Our Case Number: ABP-318573-23

Re: A proposed Road Development comprising of the N2 Slane By-Pass and Public Realm Enhancement Scheme
Within the Townlands of Slane, County Meath

Our Ref: SID-MH-2023-42

N2 Slane Bypass and Public Realm Enhancement Scheme

Title
CULVERTS 6A, 6B AND 6C
LAYOUT PLAN

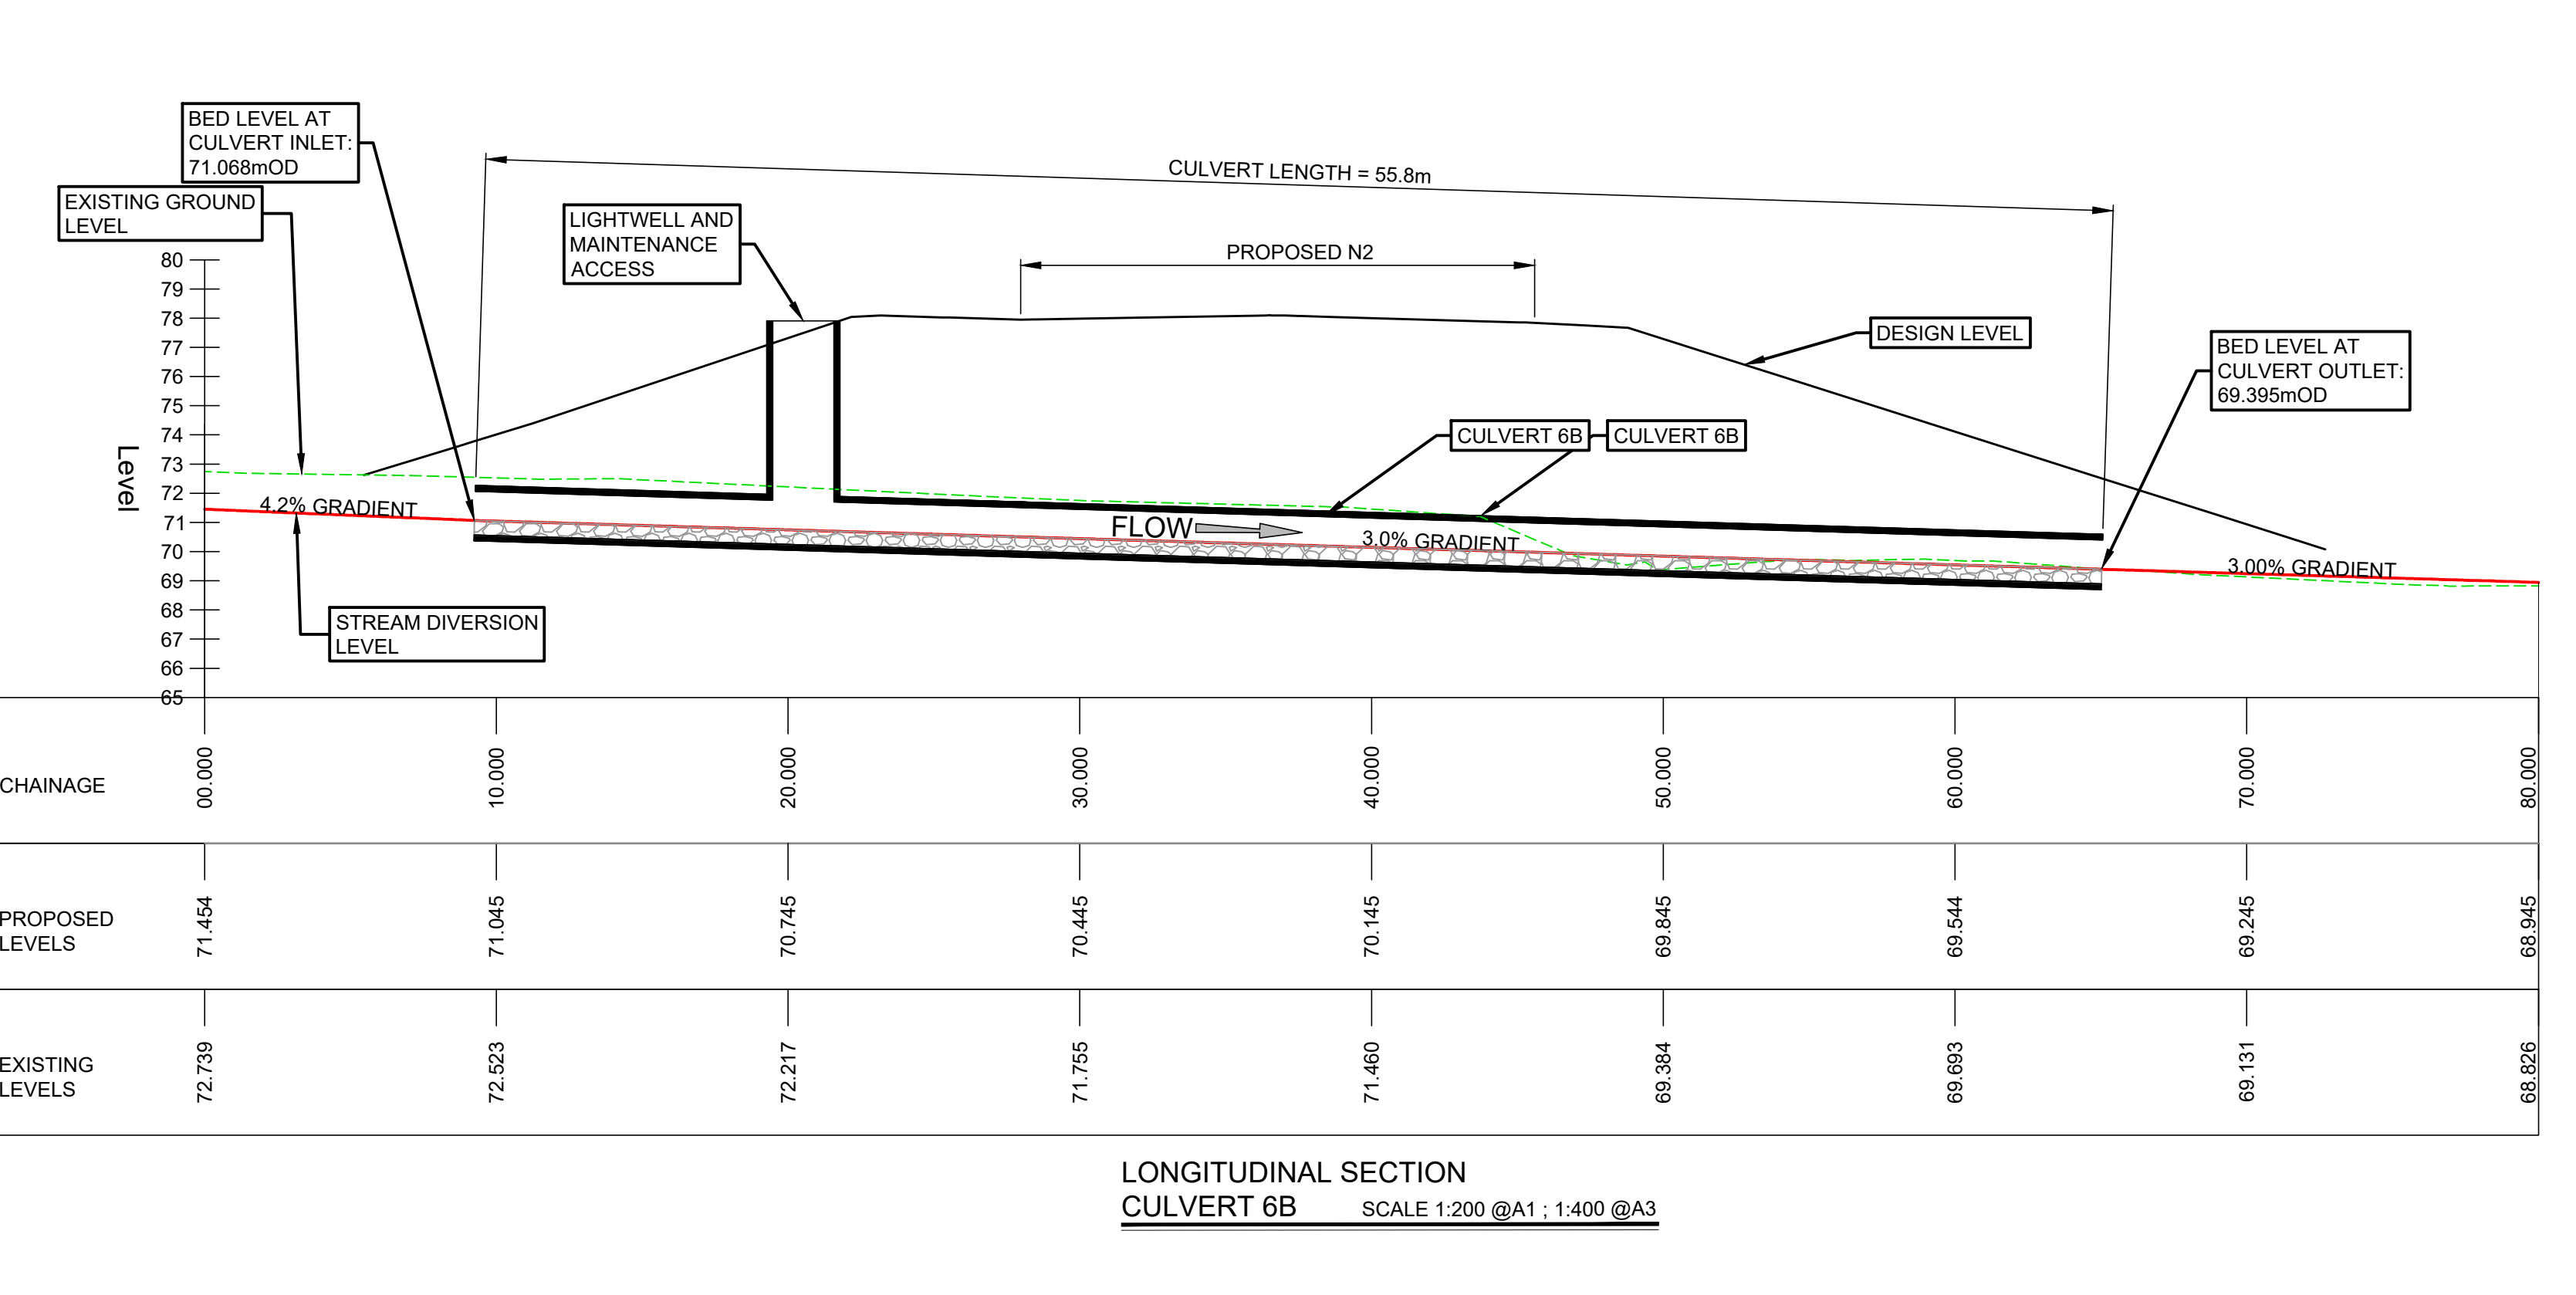
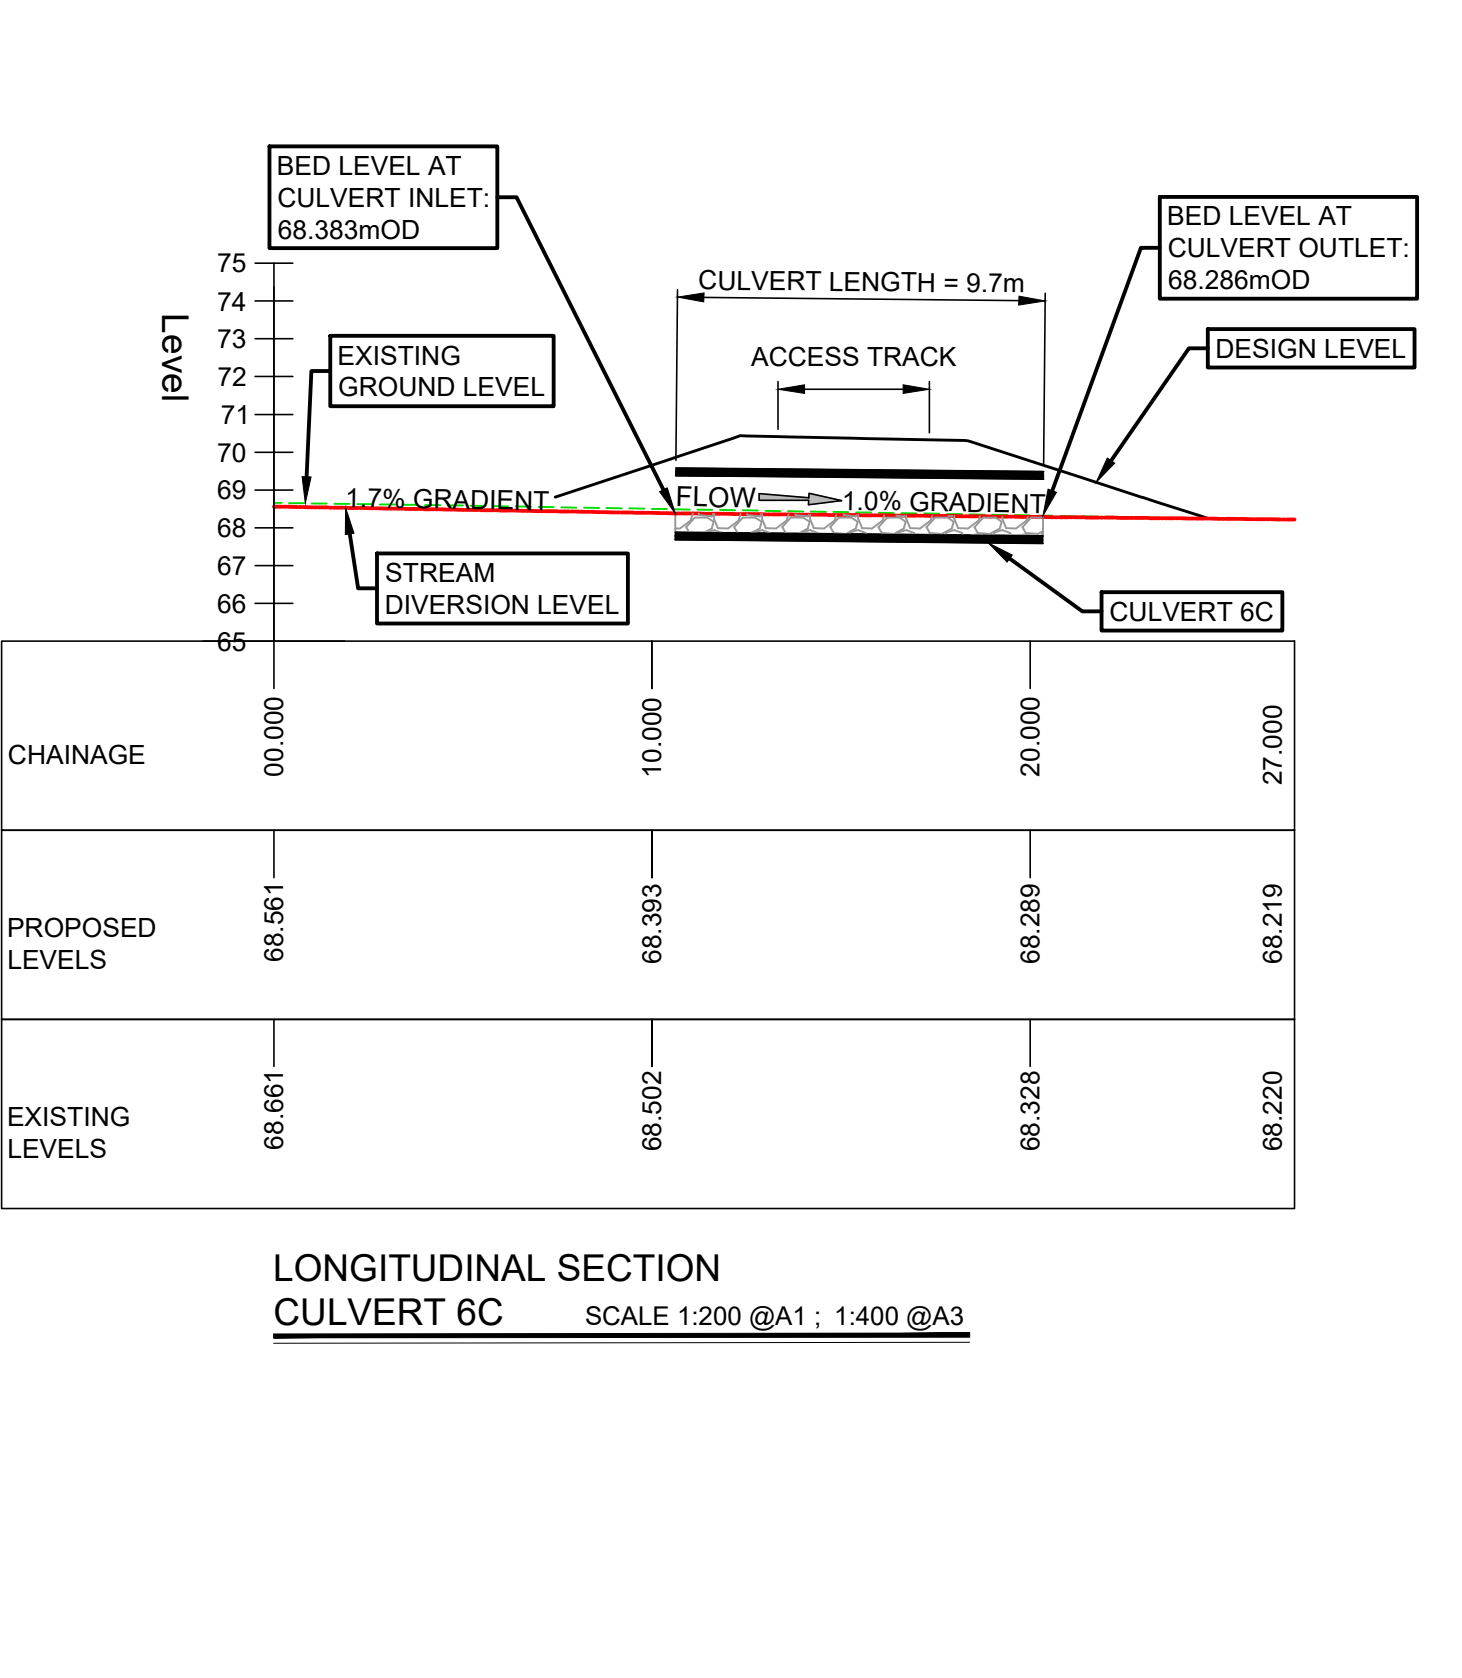
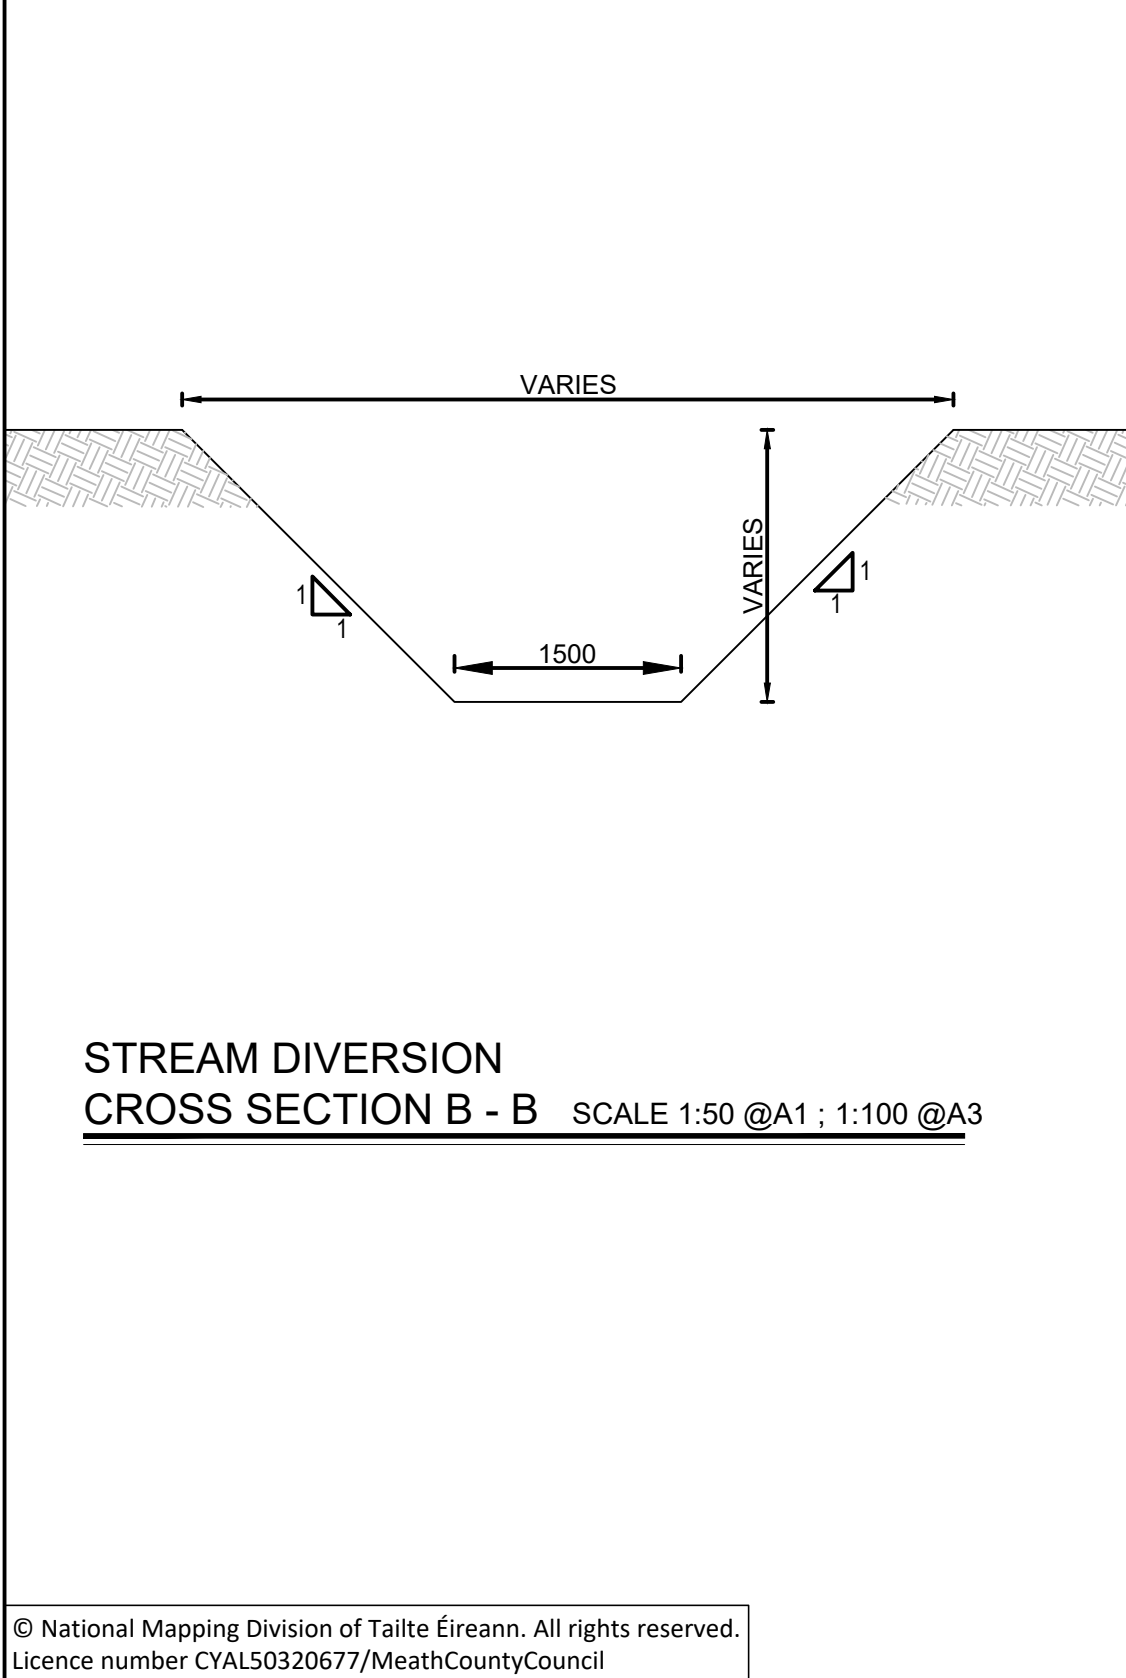
This Department notes that construction of the northern tie-in to the N2 will require construction of a sequence of culverts for the Mattock (Mooretown) Stream, an upper tributary of the River Mattock. A section of this watercourse is already culverted to accommodate the existing N2 road, this is existing culvert will need to be extended, in addition to the construction of new culverts (Culverts 6A–C: see EIAR Sections 5.4.7.4; 5.4.8.3; 5.12.2; 5.12.9.2). These works will require the temporary diversion of the Mattock (Mooretown) Stream and some in-stream works. The affected sections of the watercourse are in proximity to Recorded Monument ME019-013---- (Souterrain) and undesignated sites ACH12, ACH21, ACH38, ACH28 (as described in Chapter 13 of the EIAR). There is a potential for direct negative effects to underwater archaeology from culverting of the watercourse. NMS notes that this is not discussed or considered in Chapter 13 of the EIAR.

2. The developer shall commission a pre-construction Underwater Archaeological Impact Assessment (UAIA) report to include the following:
 - a. A licenced wade assessment, accompanied by a hand-held metal detection survey, centred on the area(s) where works are proposed within the Mattock (Mooretown) Stream. A Dive/Survey licence (Section 3 1987 National Monuments Act) and Detection Device consent (Section 2 1987 National Monuments Act) will be required for the wade survey and metal detection, respectively.
